Your Ref: OWPC18870
Our Ref: R/107/18/PDH 20-05-2018
Please ask for:
Amber Willard

Notification under extended permitted development rights for a single storey rear extension extending 6.5m from the rear of the original dwelling house, with a maximum height of 2.85m & an eaves height of 2.85m.

23 Preston Avenue Rustington

Thank you for your internet representation made on 13th June 2018 which has been recorded as **'an objection'** with the comments as follows:

SECTION AA EXISTING SIDE ADDITION

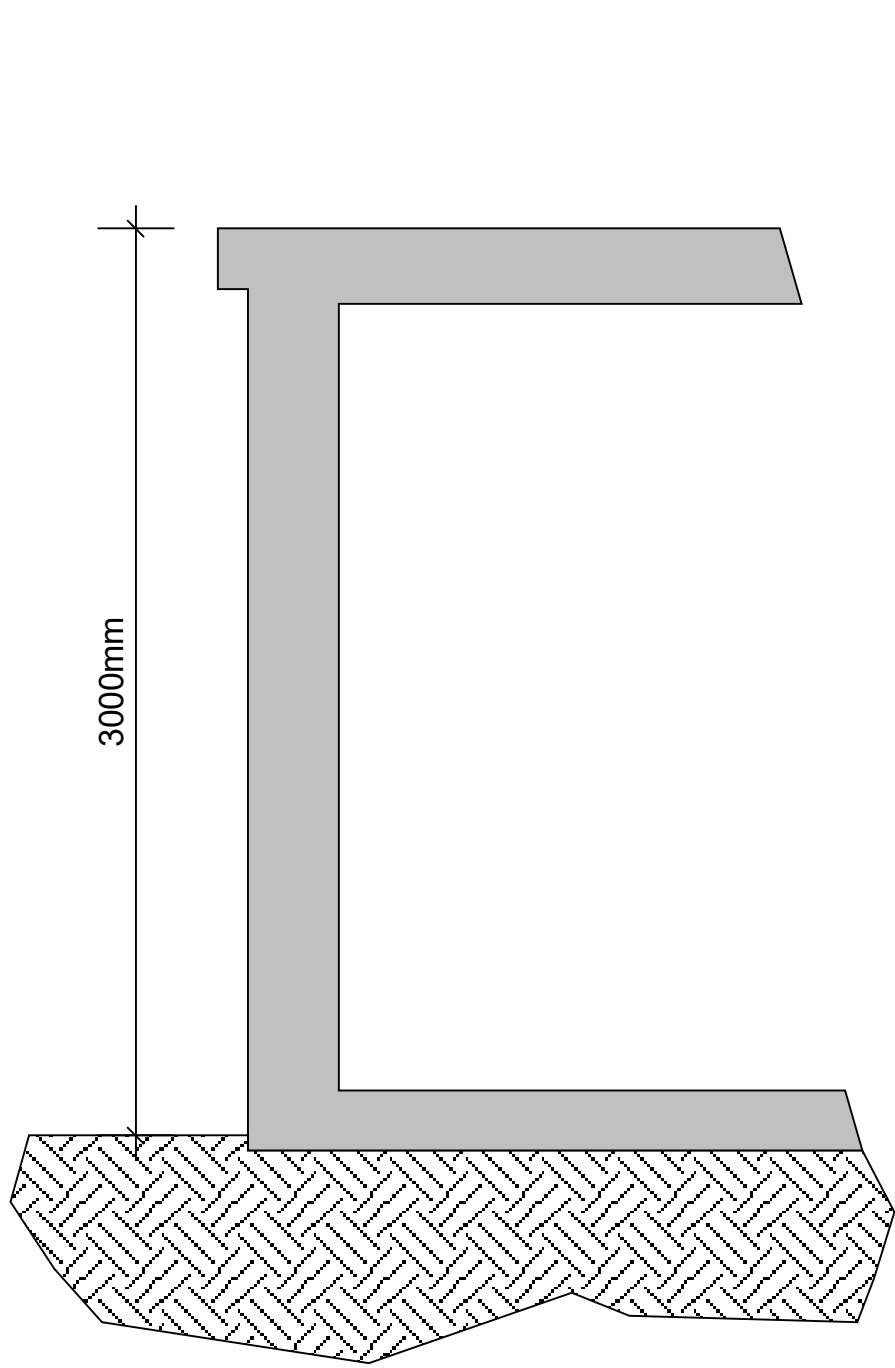
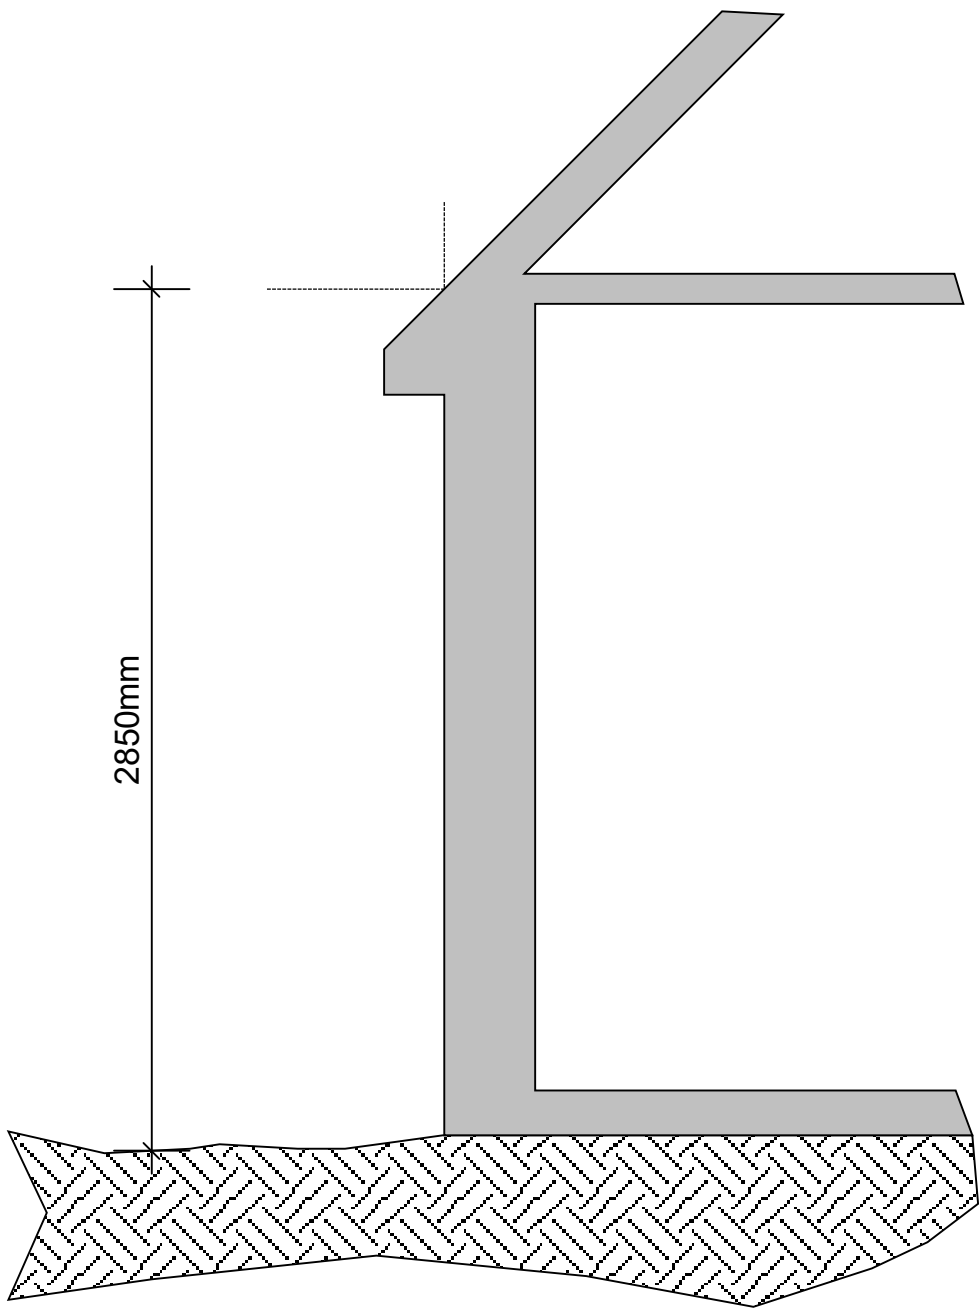
- Does not comply with Sch. 2 Part 1 A1(d) - the height of 2.85m is higher than the 2.4m eaves height of the property (single storey bungalow). An existing height of 2.8m applies only to the garage/workshop extension of 1968.*
- Does not comply with A1(k)(iv) in that a new extension with roof height of 2.85m would mean altering the main roof to link extension above the present 2.4m eaves height.*

Drawing Reference:
PA.CON.FP.002

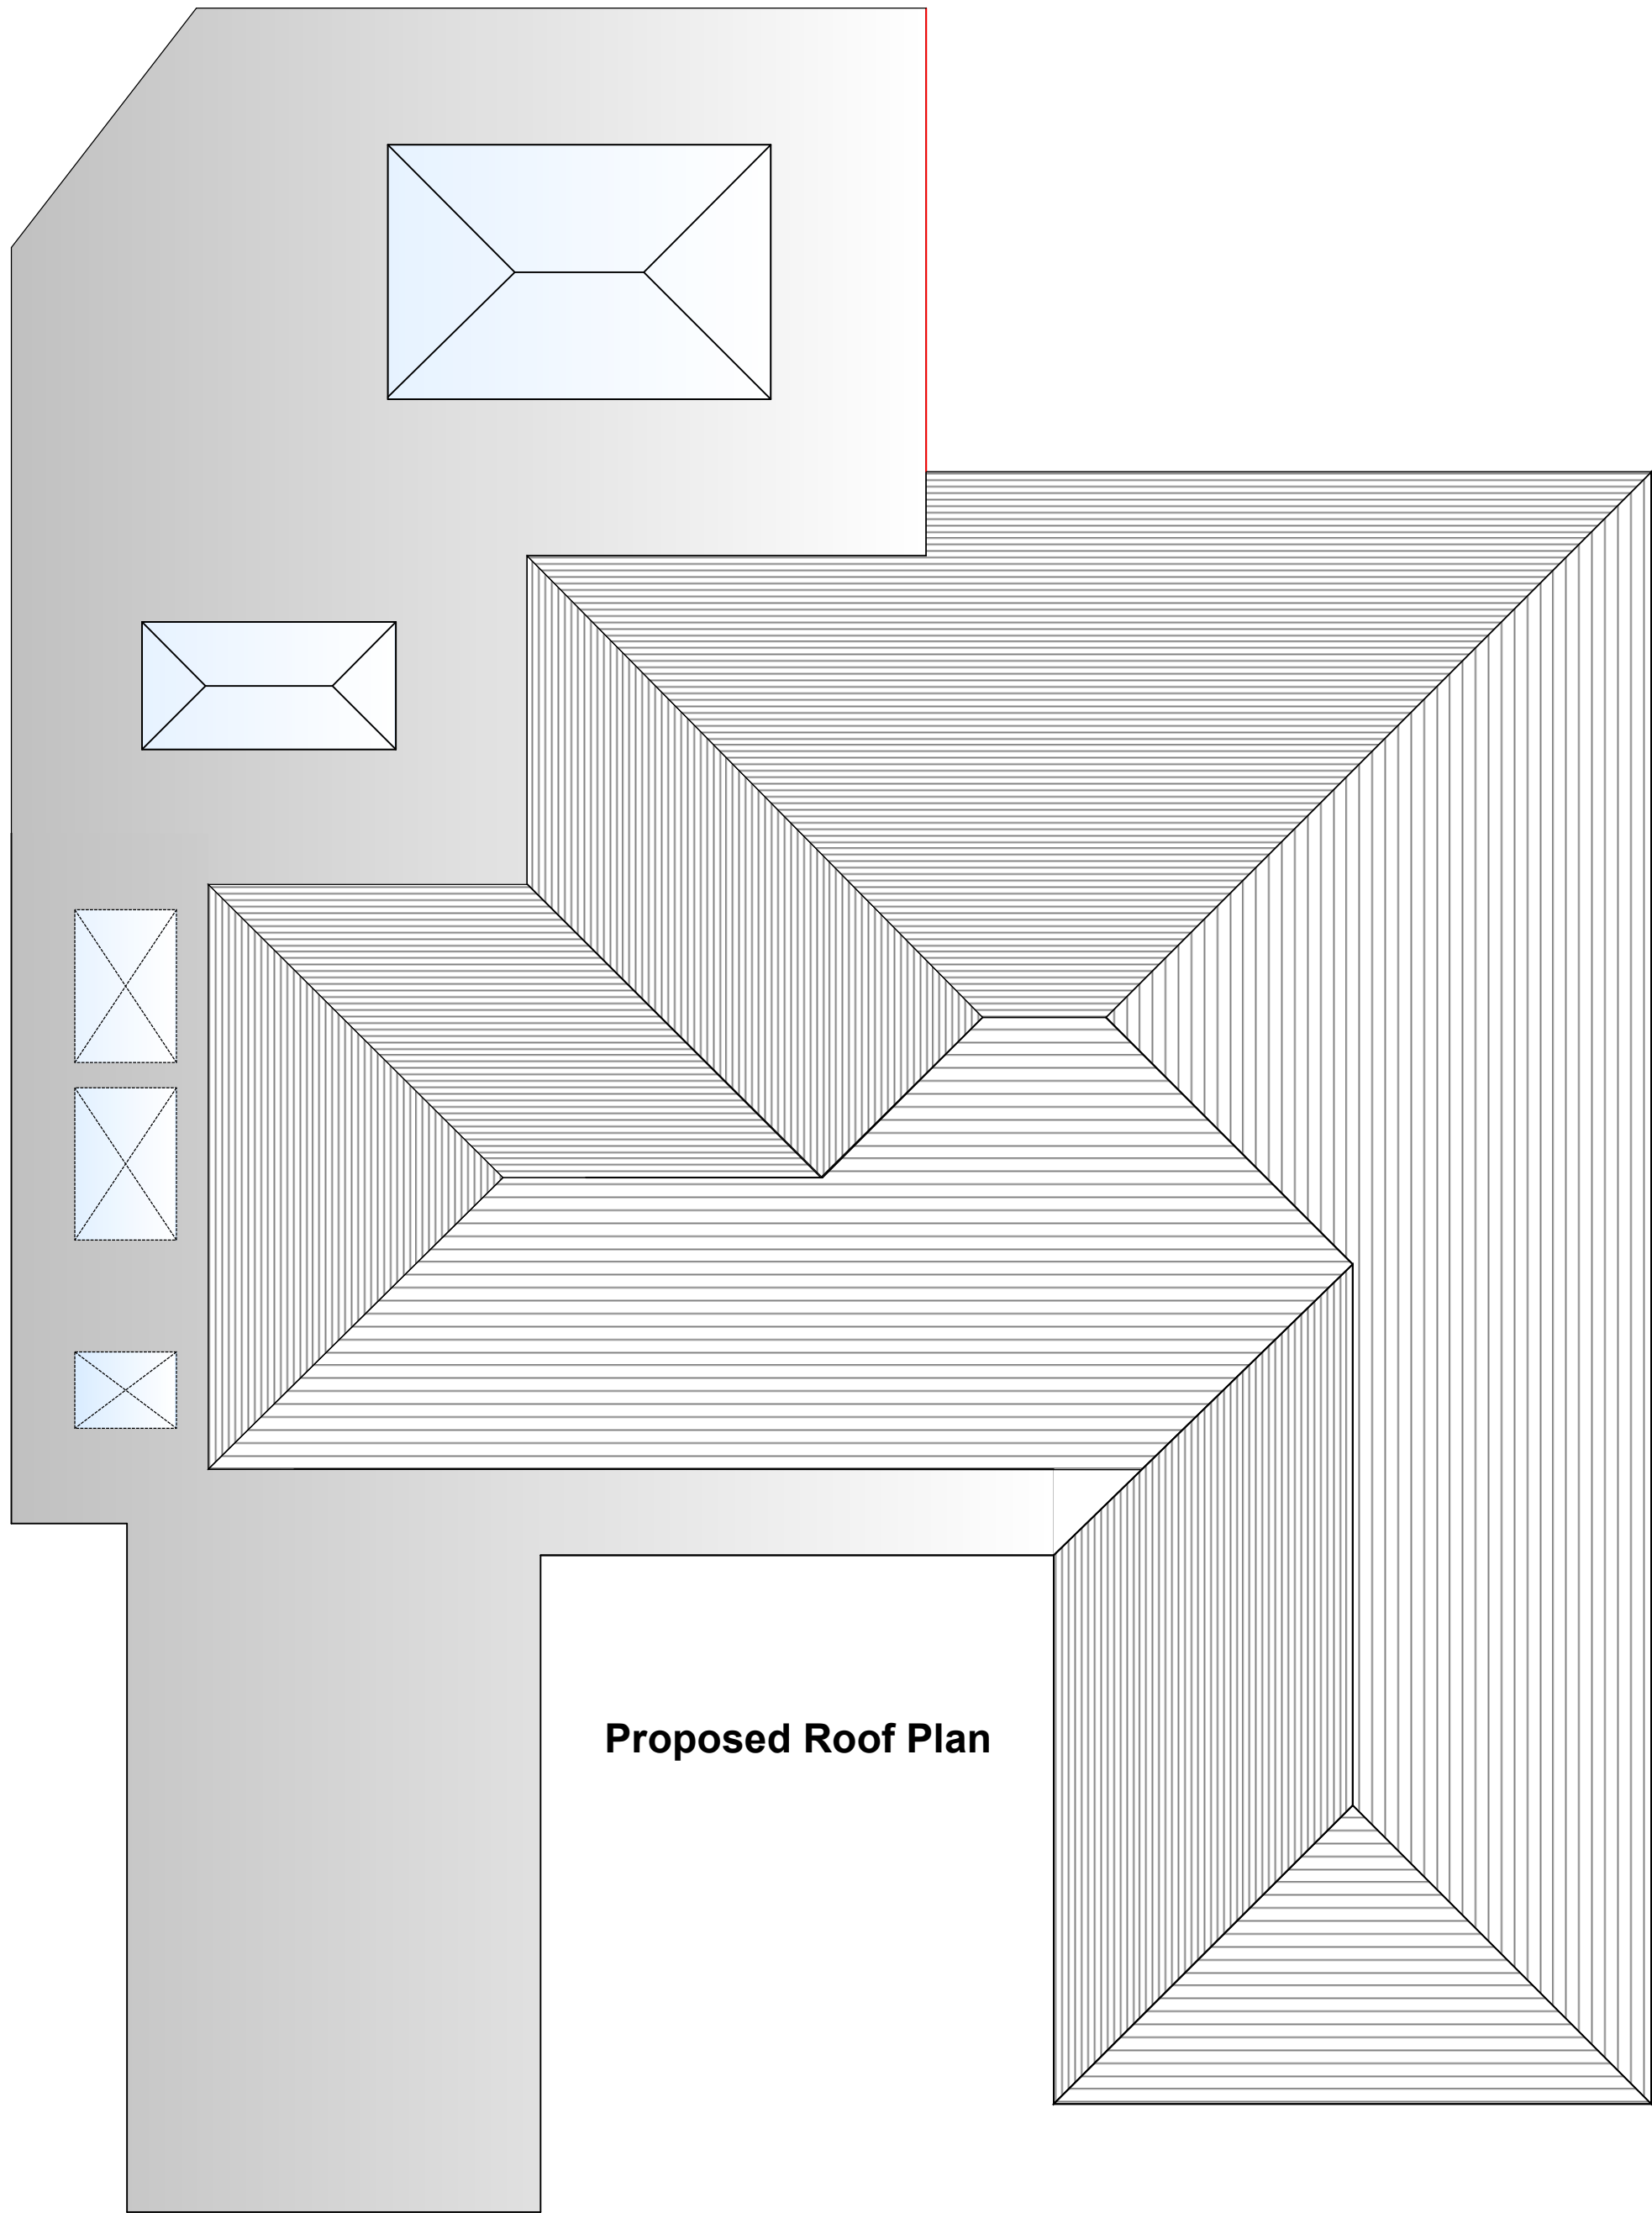
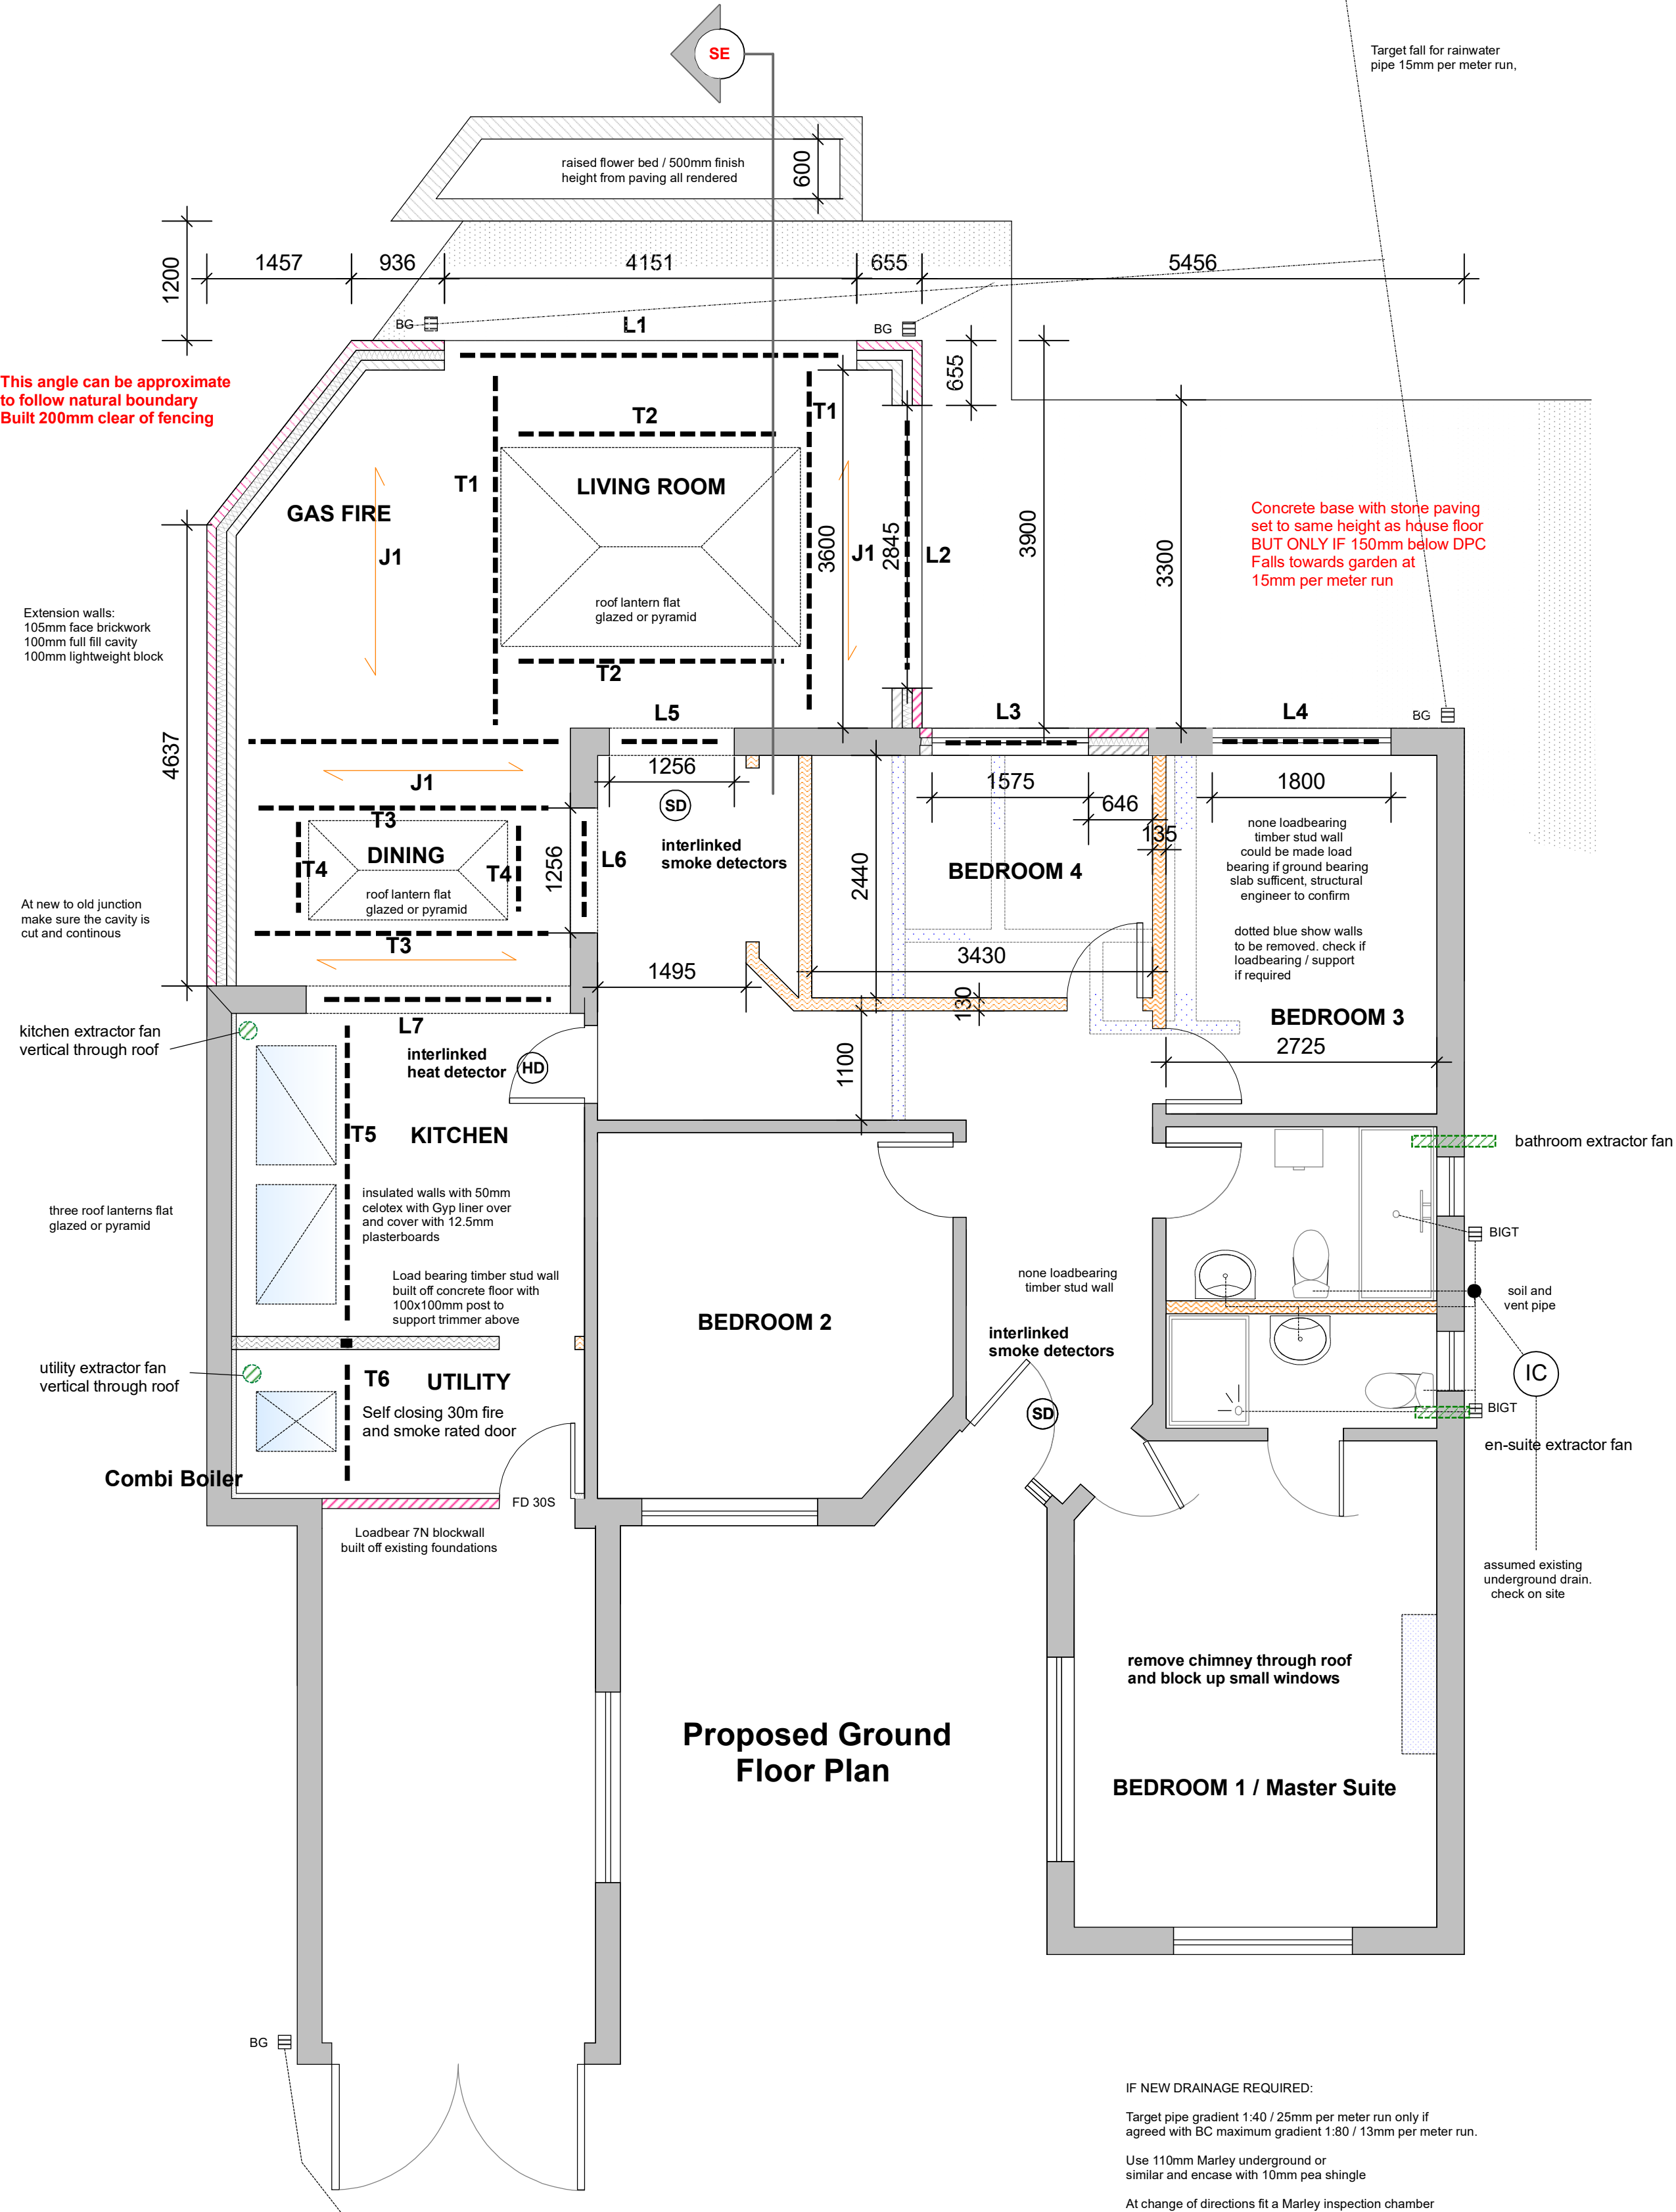
- The 5 roof lanterns planned would further increase the height and increase adverse visual impact. Lanterns on any revised proposal should be unobtrusive. Roof lanterns in main living areas would add to light pollution.*

- Conversion of garage to domestic use with solid walls built immediately adjacent to 2 adjoining boundaries is both intrusive and out of character with other properties on the Estate. The group of properties in Preston Ave & Parkway have Restrictive Covenants from when the plots were sold in 1950s stipulating no building within 4 feet of boundary. The block plan is somewhat misleading in that the constructions adjoining boundary at No.23 is a conservatory with garage on the West side, and Nos.25/27 are conservatories, not solid wall domestic buildings.*

- Any revised extension should be set back from the adjoining boundaries to allow maintenance of wall and gutter, also the boundary fence which is the responsibility of No.23. Access is not possible from adjoining properties due to garden features.*
